**DE-2012/84**

**12 October 2015**

**STATE SIGNIFICANT DEVELOPMENT – RESOURCE RECOVERY FACILITY – KEMBLA GRANGE (SSD 5300) – RESPONSE TO SUBMISSIONS**

## **ATTACHMENT A - Comments on the Response to Submissions Report**

Drawing Title	PROPOSED INDUSTRIAL DEVELOPMENT LOT 10 DP 878167 WYLLIE ROAD, KEMBLA GRANGE PAVEMENT PLAN			Project No.	KF110816	
				Drawing No.	C303	
				Sheet	4 Of 20	Revision
						E
Scale	1:500 @ A1 1:1000 @ A3	Drawing Status	ISSUED FOR SSD5300 MOD2 CC

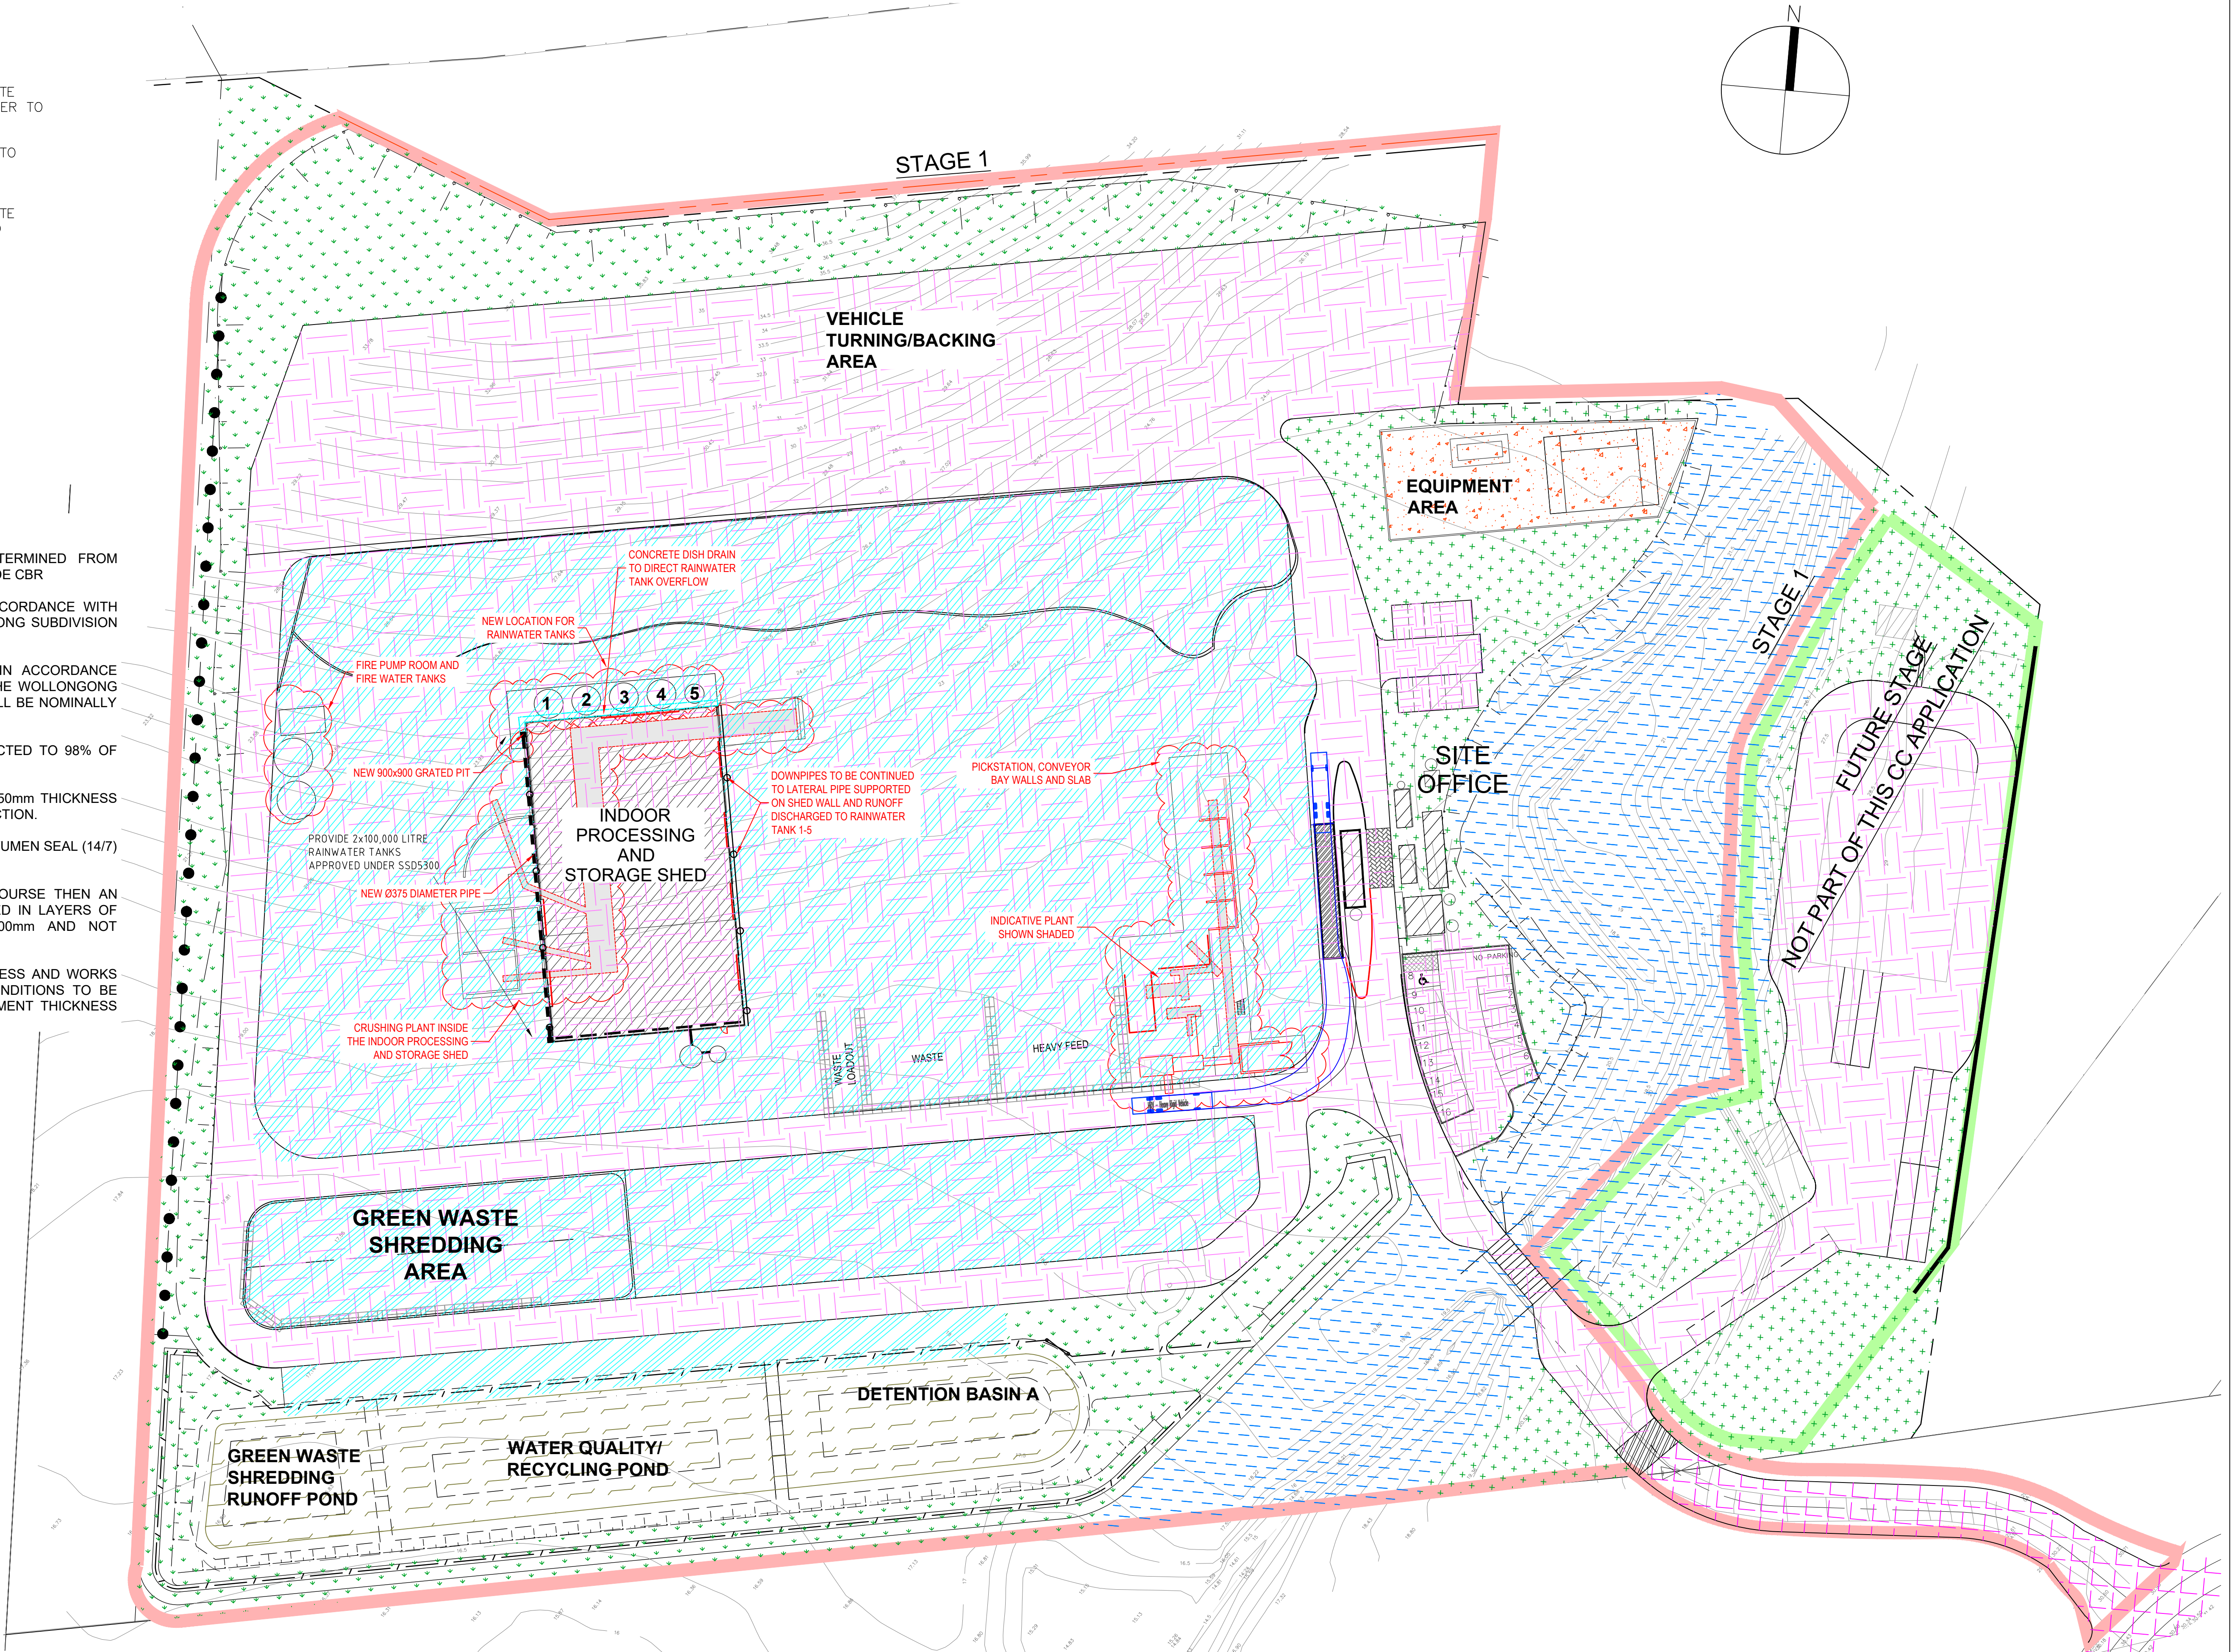
The previous comments raised in Council's letter dated 2 July 2015 relating to pavement construction have been incorporated in the Surfaces Plan, Drawing No. KF110816 C15 Revision F Sheet 6 of 18 dated 2 July 2015 prepared by K.F. Williams & Associates Pty Ltd.

Based on a review of this plan with reference to pavement note 3b, this indicates that the only practical layer thickness for DGS40 in this case would be between 150mm and 300mm. Therefore, it is considered that pavement note 5 would not be consistent with note 3b and note 5 should be removed via the inclusion of recommended condition 6.3 provided at Attachment B.

- 6.3 Pavement Note no. 5 on Drawing No. Surface Plan KF110816 C15 Revision F Sheet 6 of 18 dated 2 July 2015 prepared by K.F.Williams & Associates Pty Ltd is to be deleted from this plan.
